CITY OF ALBUQUERQUE

April 9, 2015

Starbucks, 4407 Lomas Blvd. Grading and Drainage Plan

Engineer's Stamp Date 3-27-2015 (File: J17-D012)

GRADING AND DRAINAGE PLAN

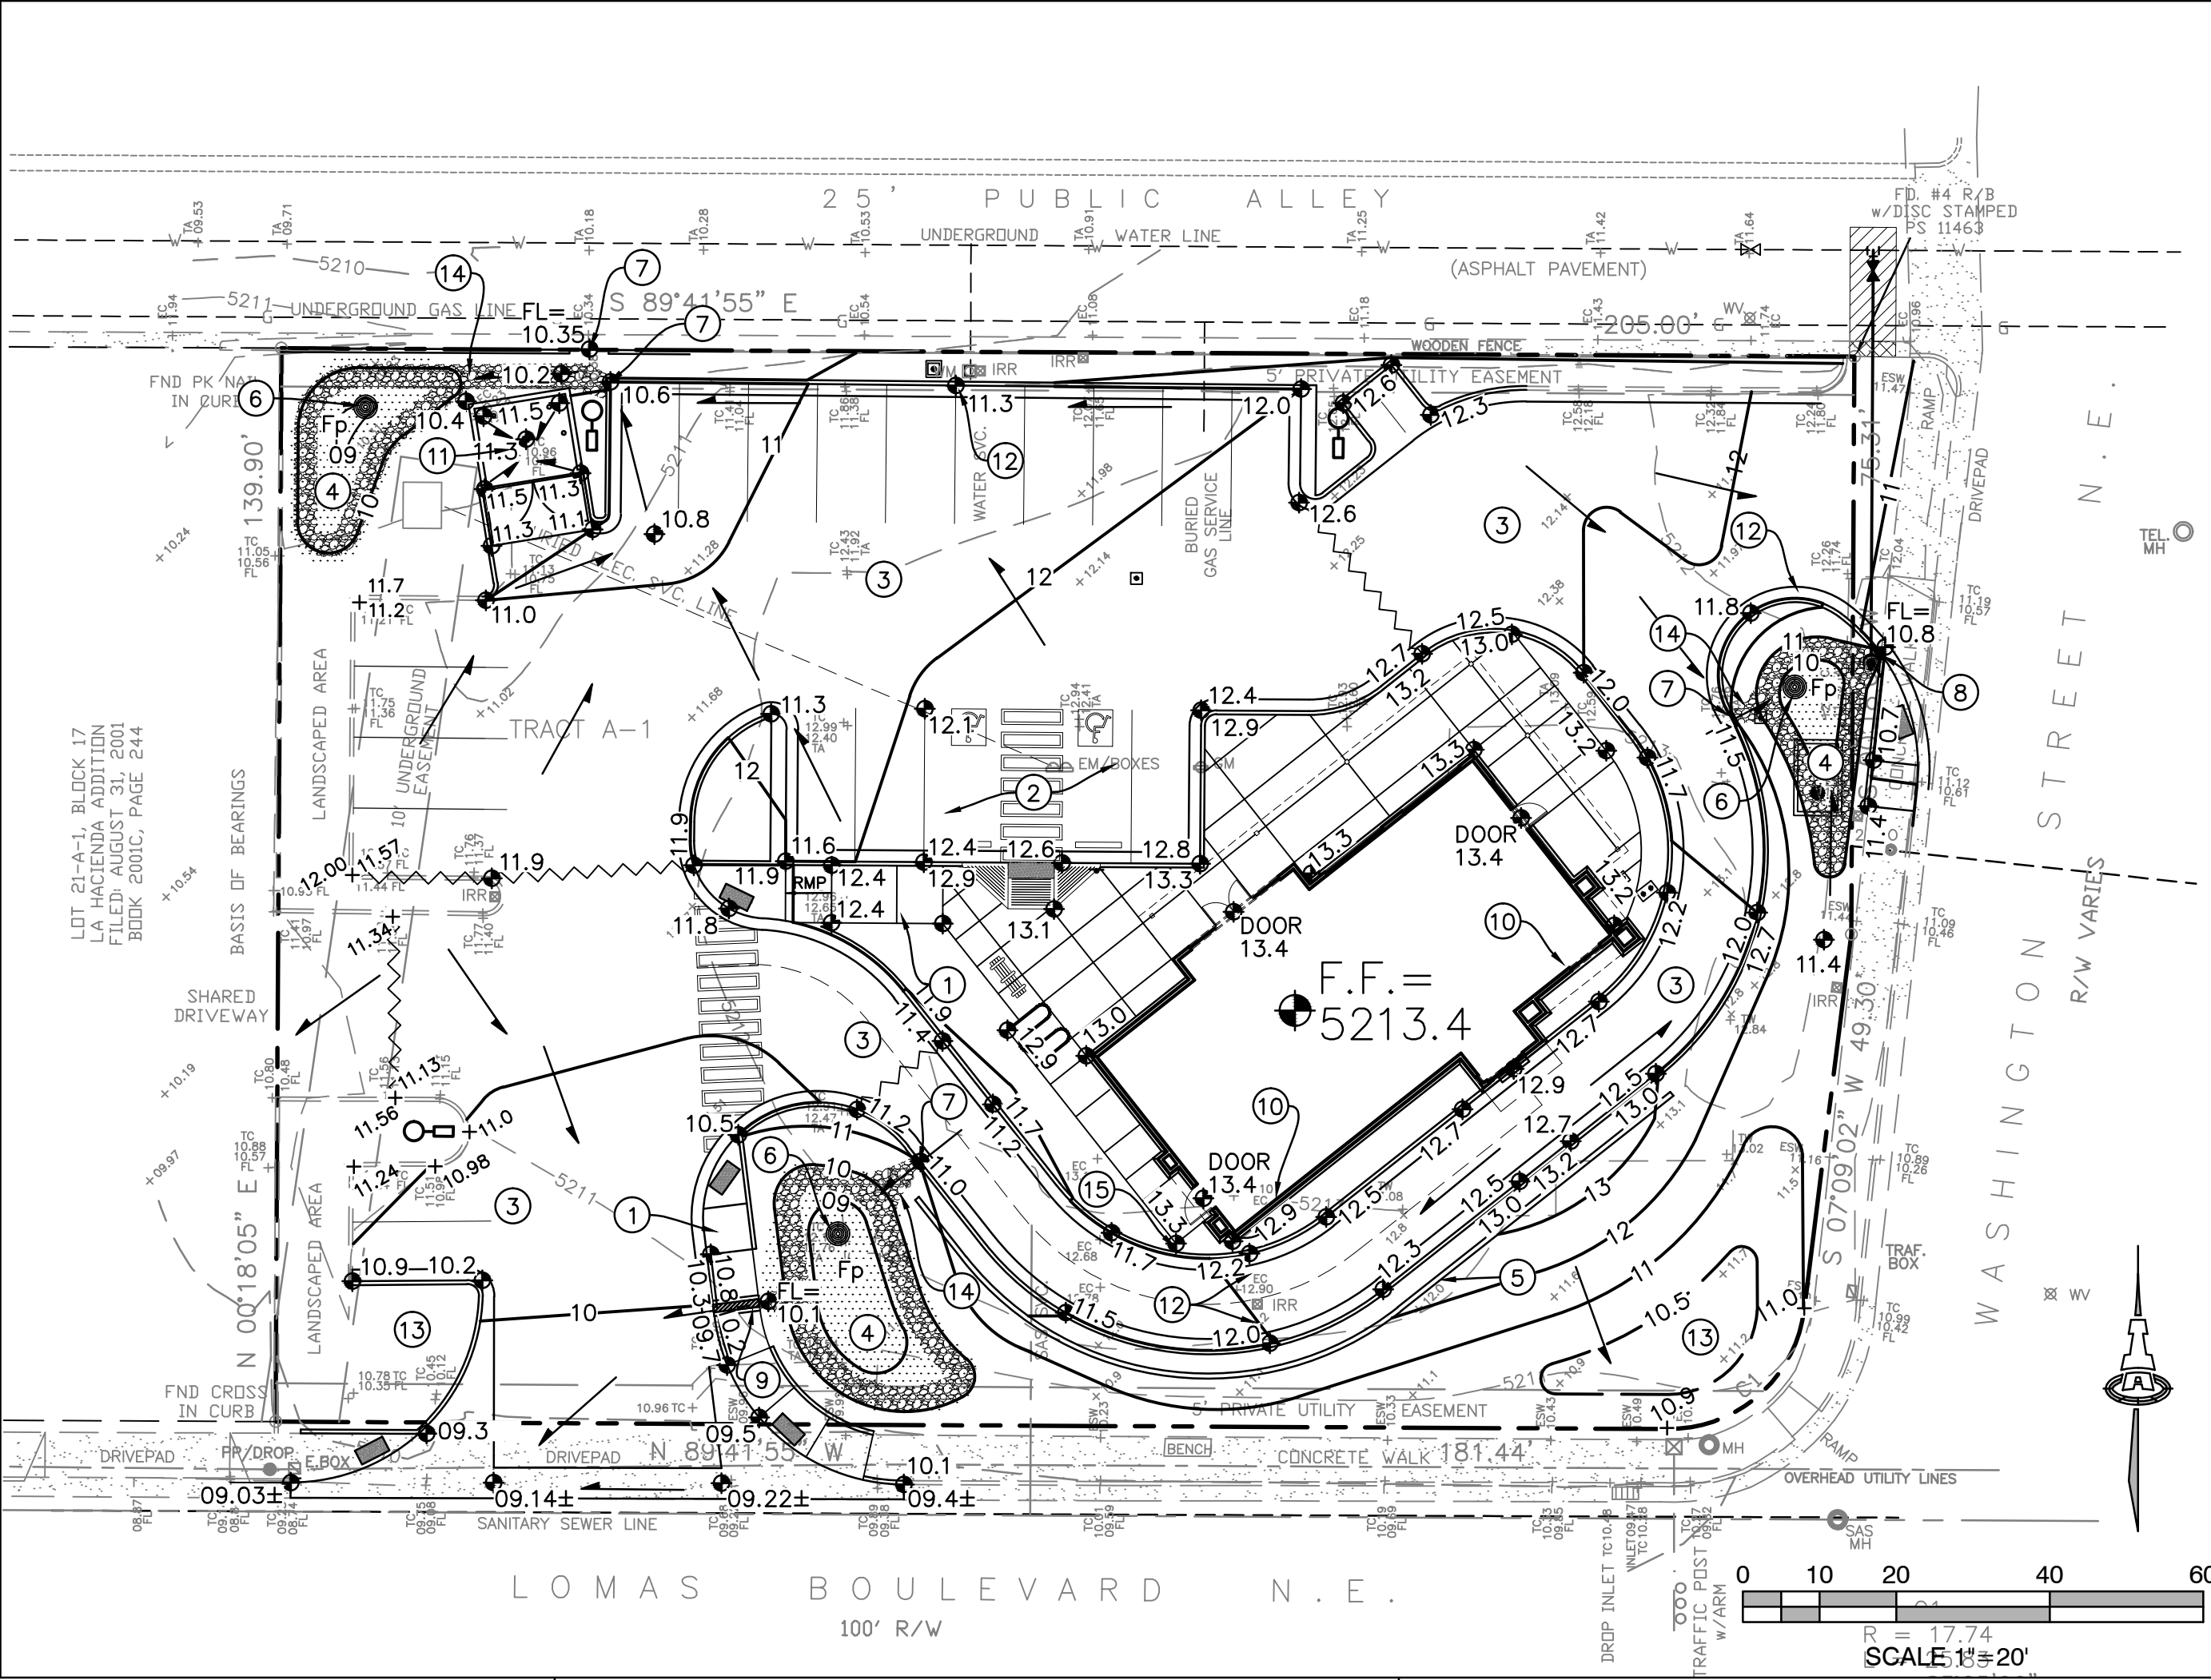
1) Under the Basin Calculations, label the associated impervious area next to the first flush volume for each of the basins. At the bottom end of the Basin Calculations Table, show the total proposed 100-year flow, the total of the impervious areas, and the total of the first flush volume.

2) Provide calculations for the existing 100-year flow for comparison to the proposed 100-year flow.

3) For each of the first flush retention ponding areas, label the volume that is being retained. Show capacity of each of the on-site sidewalk culverts and the flow that it is capturing.

4) Address any off-site impacts due to site grading with regard to the site immediately adjacent to the Starbucks site.
